SUBJECT: SX-22-00009 Schumaker

**Public Works has reviewed the Shoreline Exemption application. Please see comments below:**

BOUNDARY AND TOPOGRAPHIC SURVEY
LOT 32 OF PLAT OF KACHESS II
WITHIN THE NW1/4 OF THE NW1/4 OF SECTION 17, TOWNSHIP 21 NORTH, RANGE 13 EAST, W.M., KITTITAS COUNTY, WASHINGTON

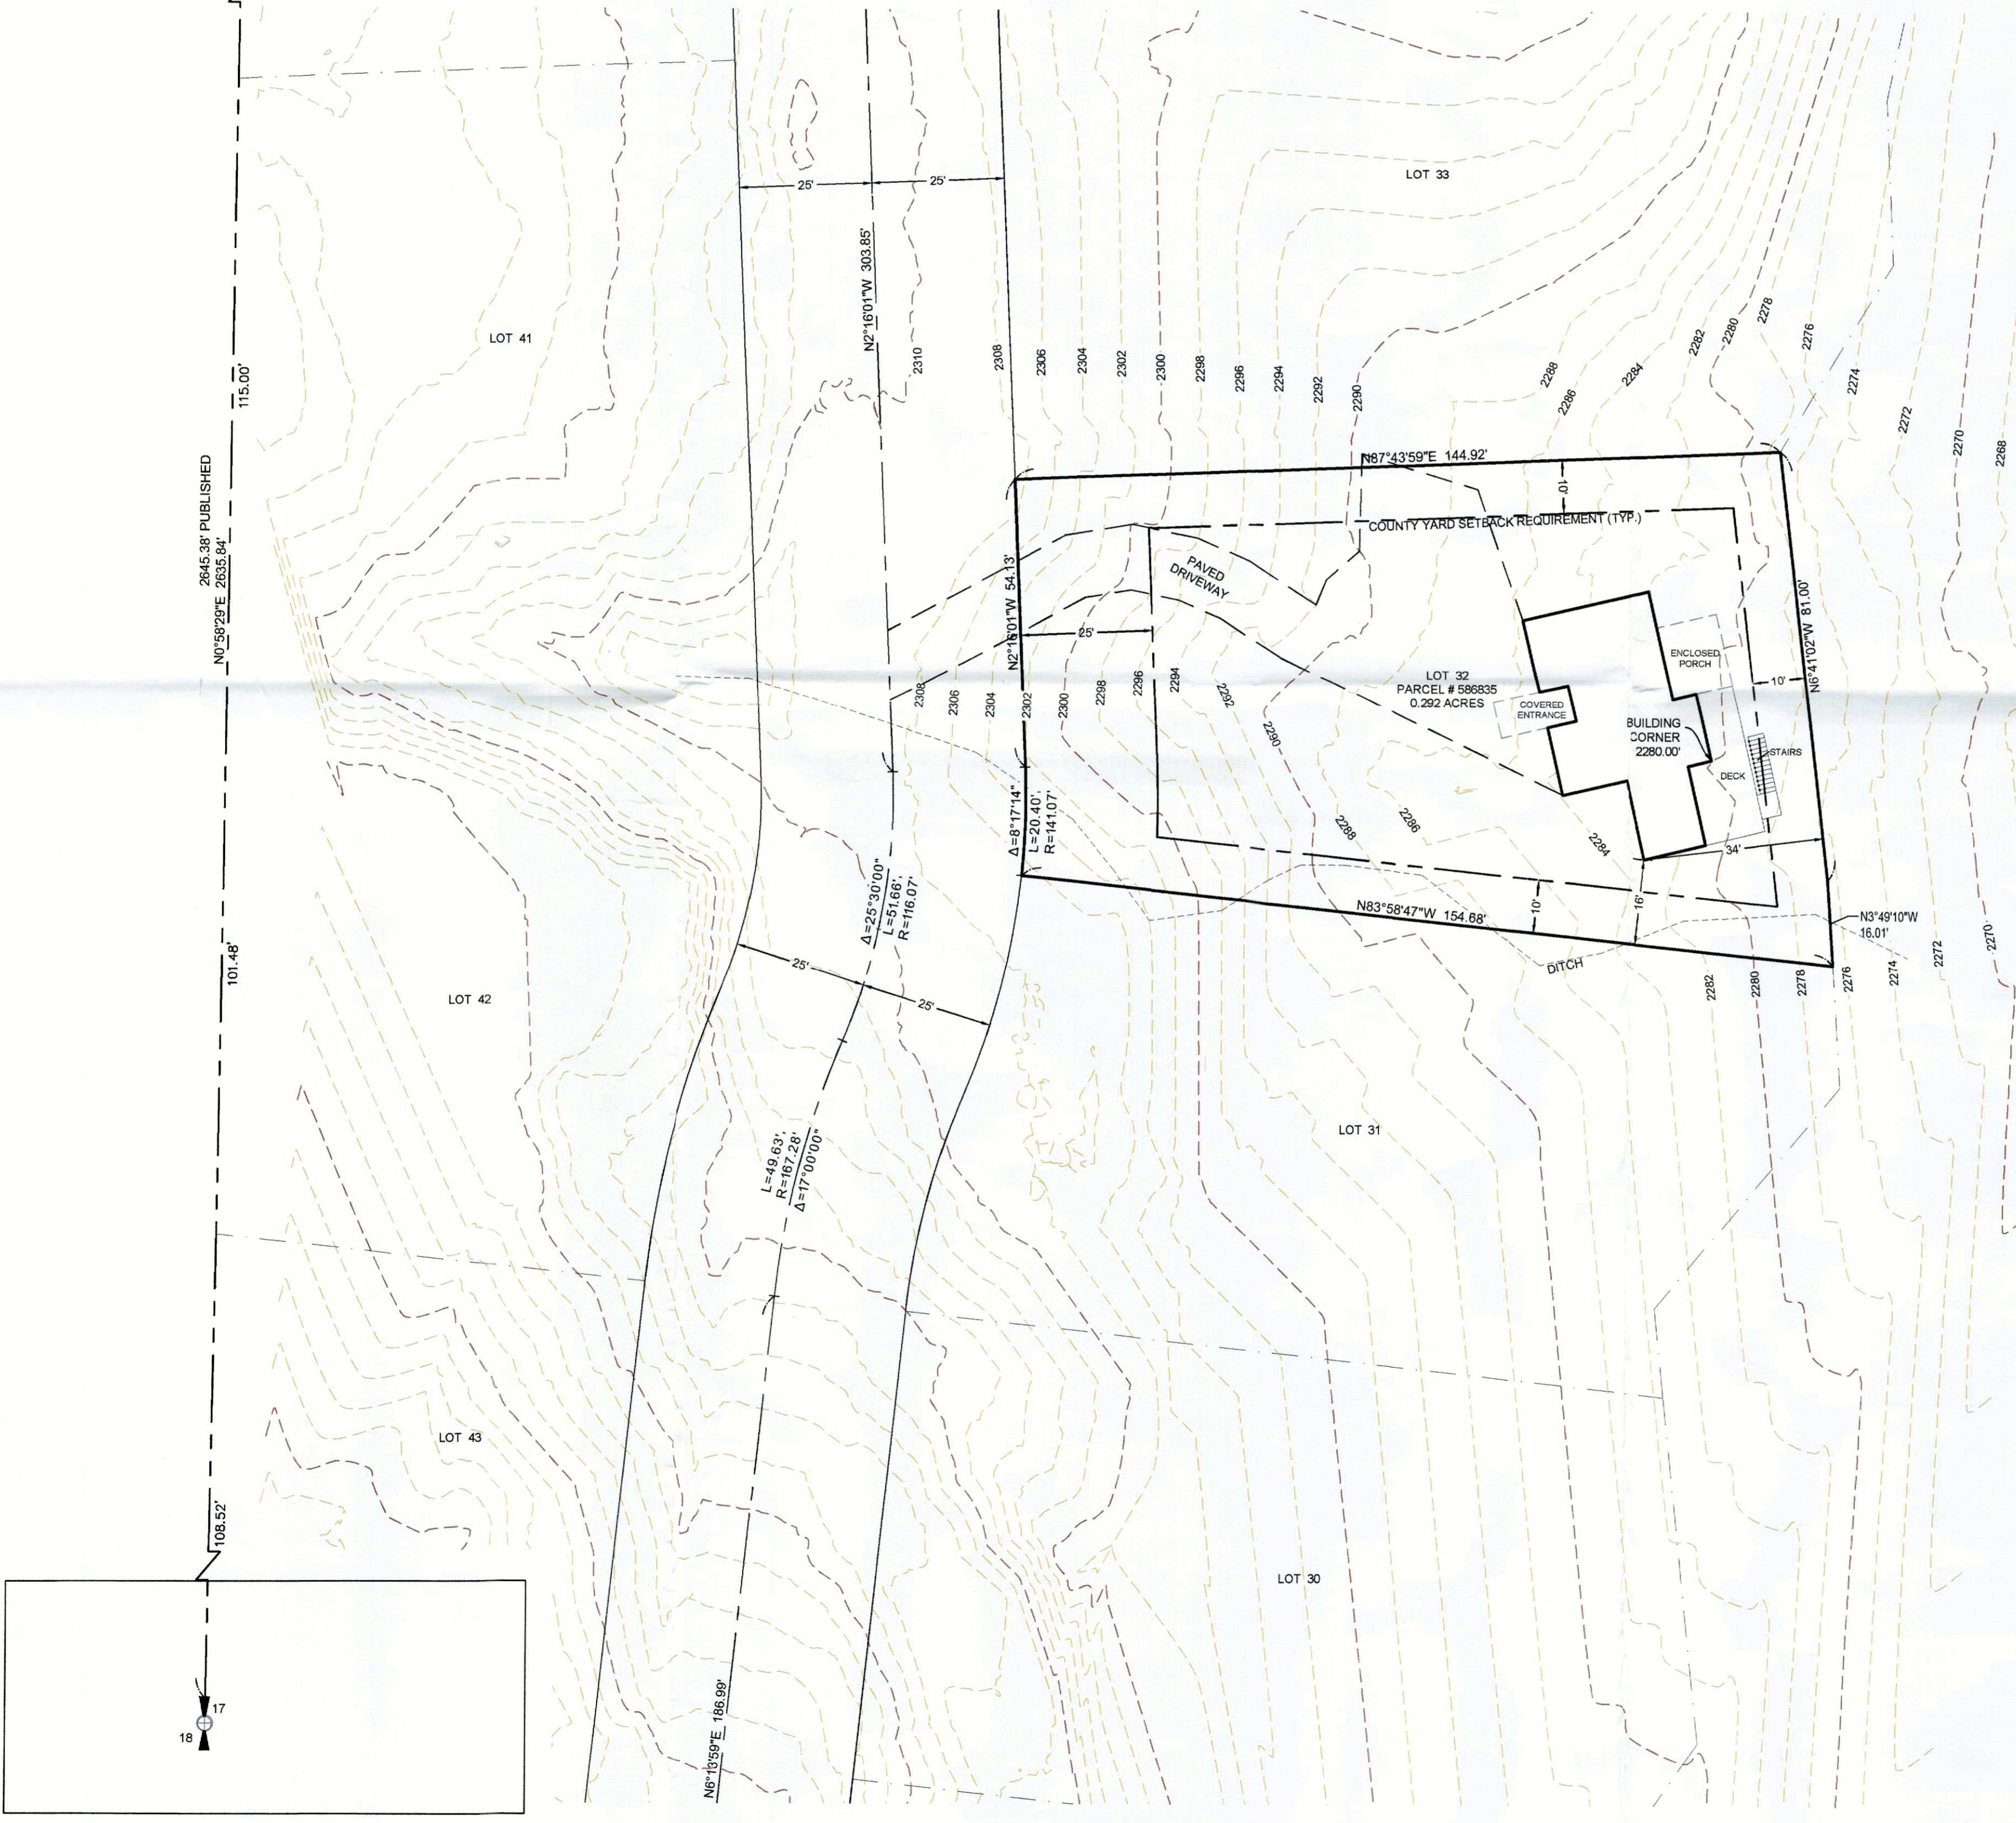
The applicant should contact Kittitas County Public Works to confirm that the proposed activity is outside the FEMA-identified Special Flood Hazard Area (the Zone A designation on the attached map). All activities within the Special Flood Hazard Area require a floodplain development permit. Since the Zone A Boundary is not shown on the attached site plan, nor can the location of the activity be deduced from the two distances provided in the correspondence about the ordinary high-water mark, we are not able to make a conclusive determination based on the information provided.
